City of Albuquerque SWPPP Inspection Checklist

Project Name:	Caliber Collision	Project Operator:	Cross Development
Project Location:	1	Contact Name:	Russell Vaughn
NPDES Permit Number:		Contact Number:	
Date of Inspection:	9/19	Contact Email:

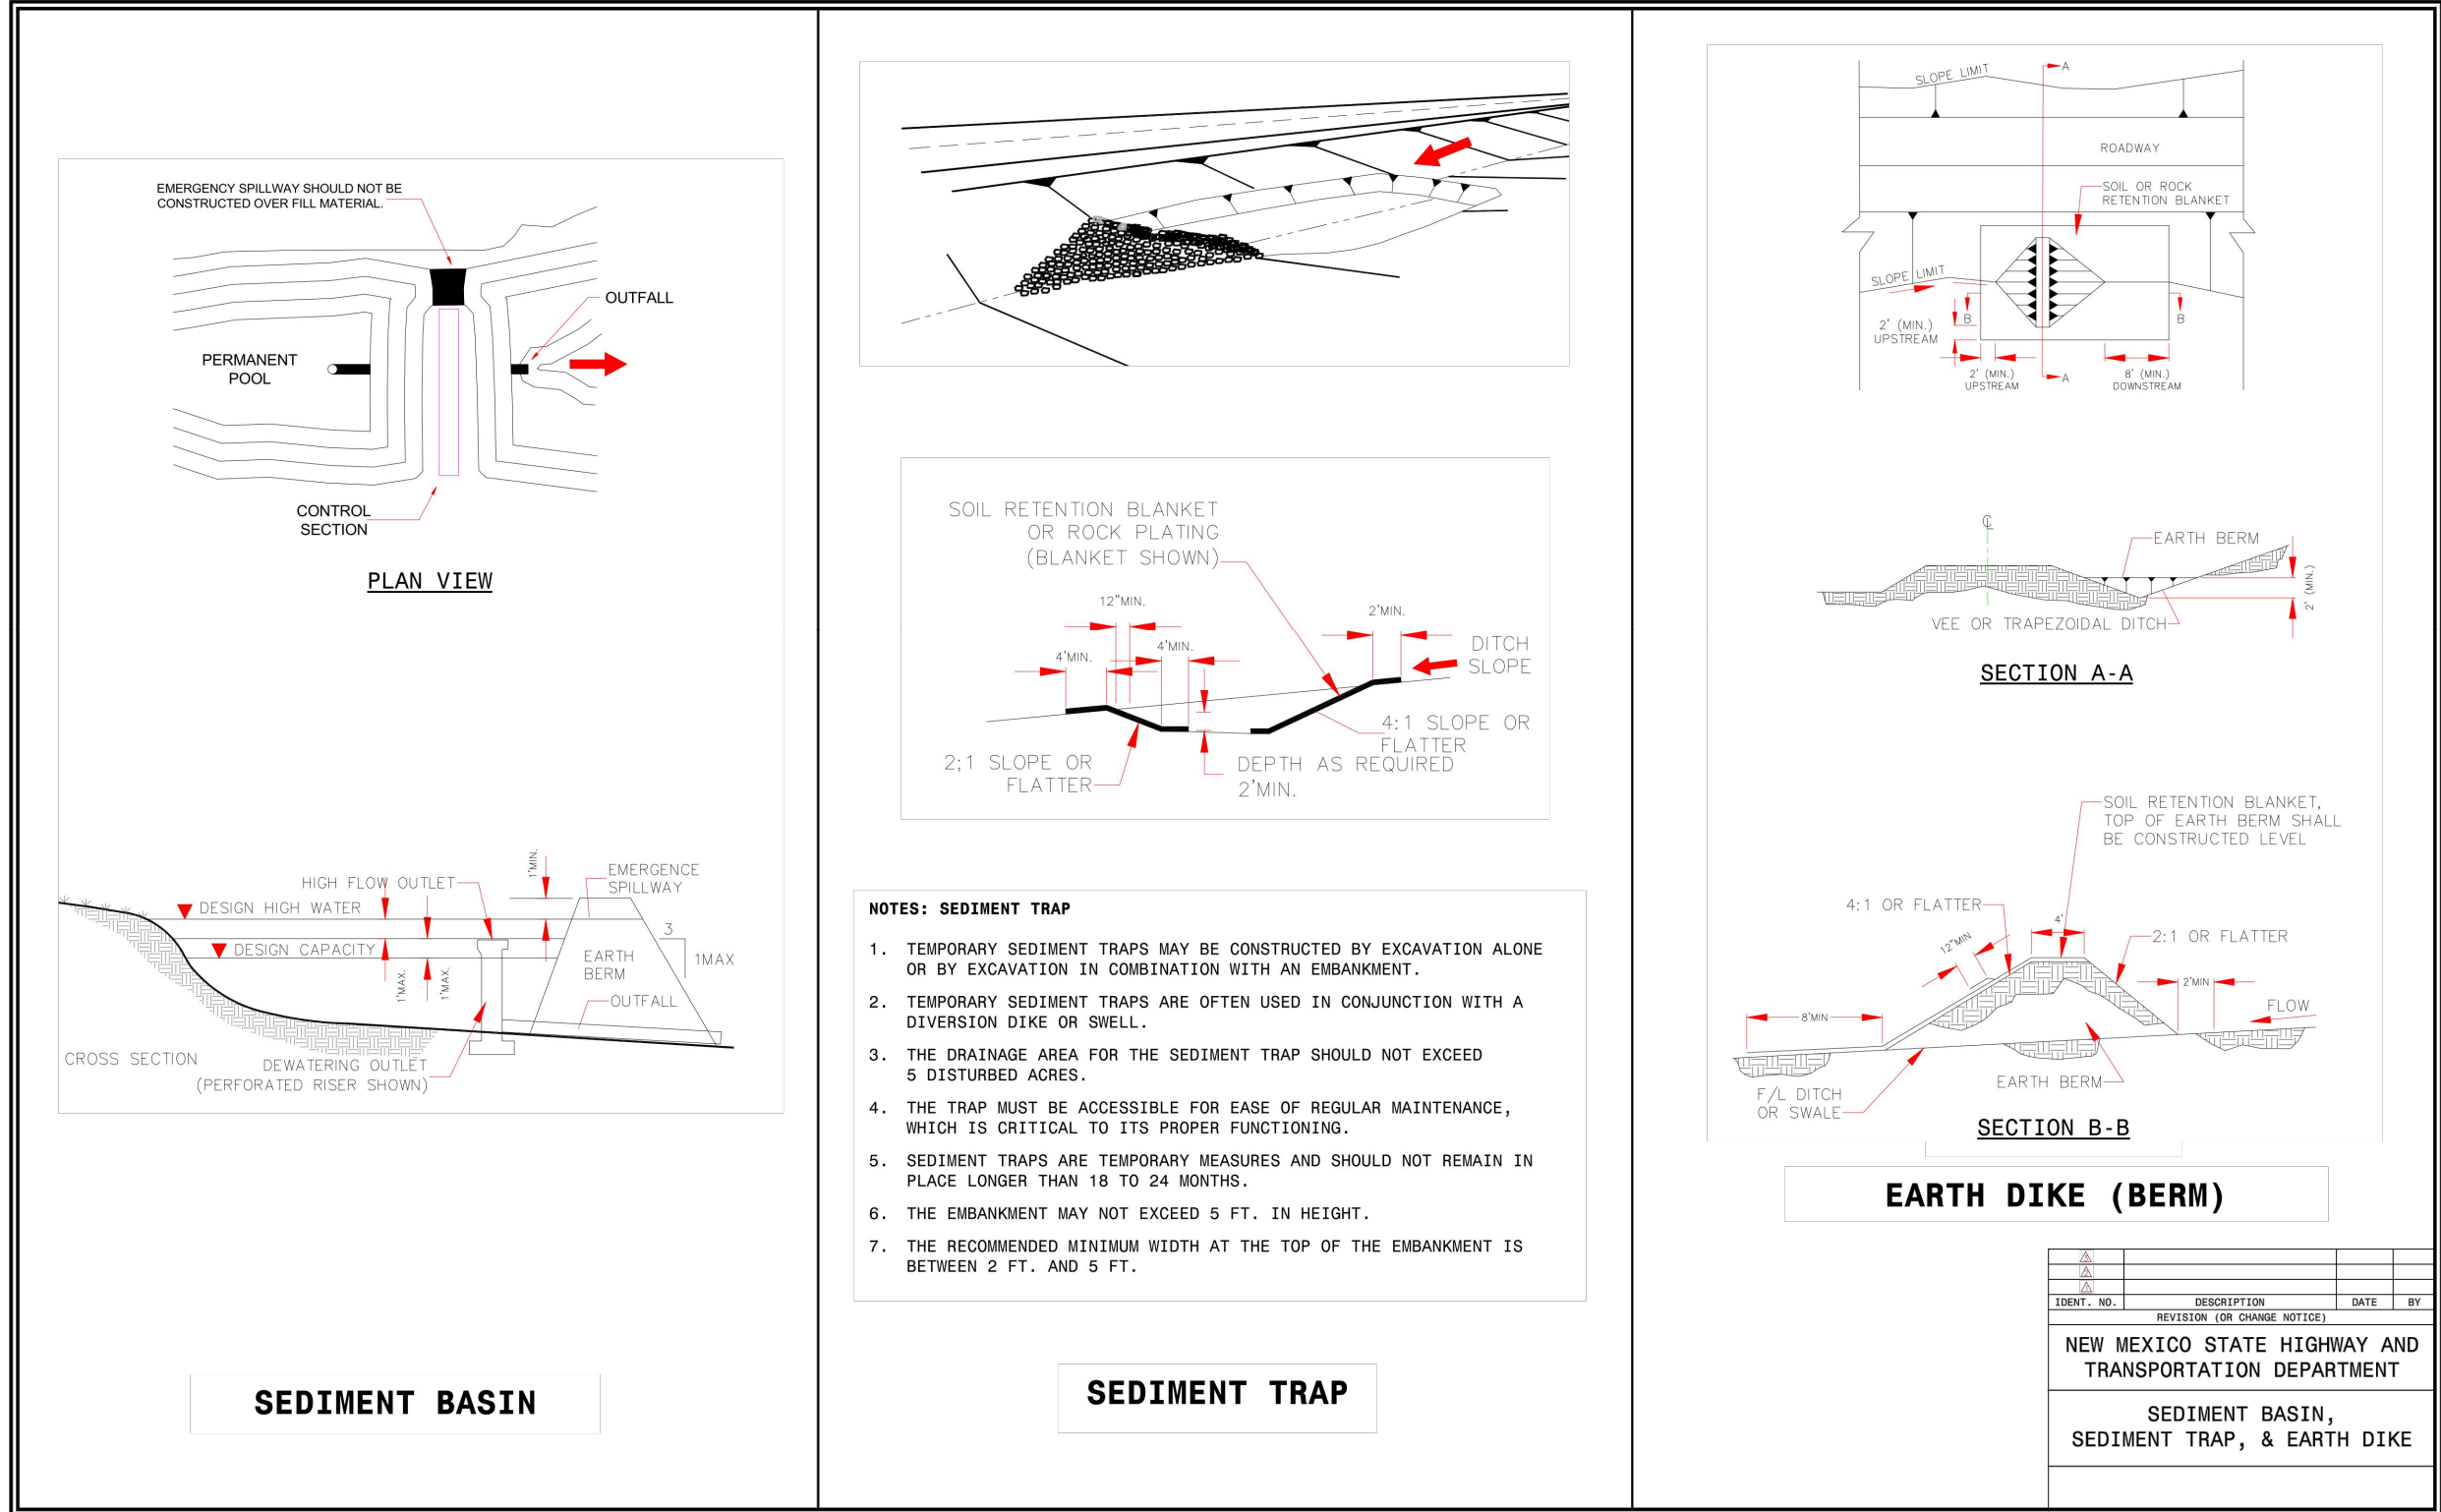
South Silt Fence Missing
